Application number: 2021/90086	
What is the application for?:	Erection of 18 apartments in 2 blocks and change of use and alterations to convey
Address of the site or building:	Grameen Spice, 2, Briestfield Road, Grange Moor, Huddersfield, WF4 4DX
Postcode:	DY4 7AL

GRANGE MOOR COMMUNITY ASSOCIATION - COMMENTS ON REVISED PROPOSAL

Project	Proposed Residential Development of 20 No Apartments at The New Inn, 2 Briestfield Road, Grange Moor, WF4 4DX for Mr B Sangha	01924 380873	ZZ R L
Drawing	Proposed Site Layout	Date 11/03/2020	
		Drg No

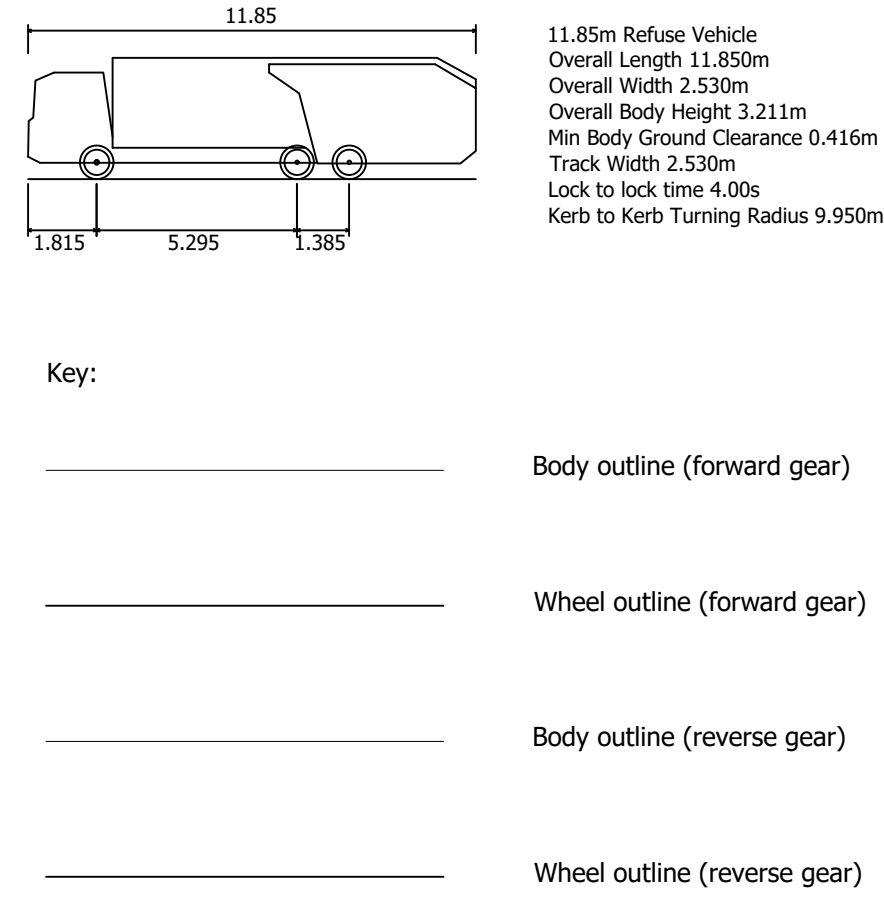
Parking continues to be a problem of safety and concern where the developers have a planned allocation of just one parking space for each flat

There is an allocation of one parking space per dwelling with the site layout showing an additional 5 visitor parking spaces. However having the visitor places located almost all to the back of the site it is more likely that due to the density of this proposal parking will not be sufficient. Further it can be expected that properties although listed as having one bedroom will be occupied by families having more than one vehicle per household.

It is more likely, that due to the shortage on space on this proposal, that there will not be sufficient free area to park the excess number of vehicles expected to be generated by visitors to the properties.

This will force vehicles to occupy street parking on Briestfield Road where there is limited parking for approx 15 cars. Also this will cause visibility issues along the this stretch of Briestfield Road causing concern for the safety of pedestrians. In addition at times during the day there will be school children in the vicinity of Briestfield Road who will need a clear vision of this road busy with vehicles. It has to be realised that this will create an unsafe road for pedestrians and all other vehicles using this stretch of Briestfield Road which is the main access to the village from the very busy Liley Lane which is commonly used as a feeder road between the M1 and M62 motorways
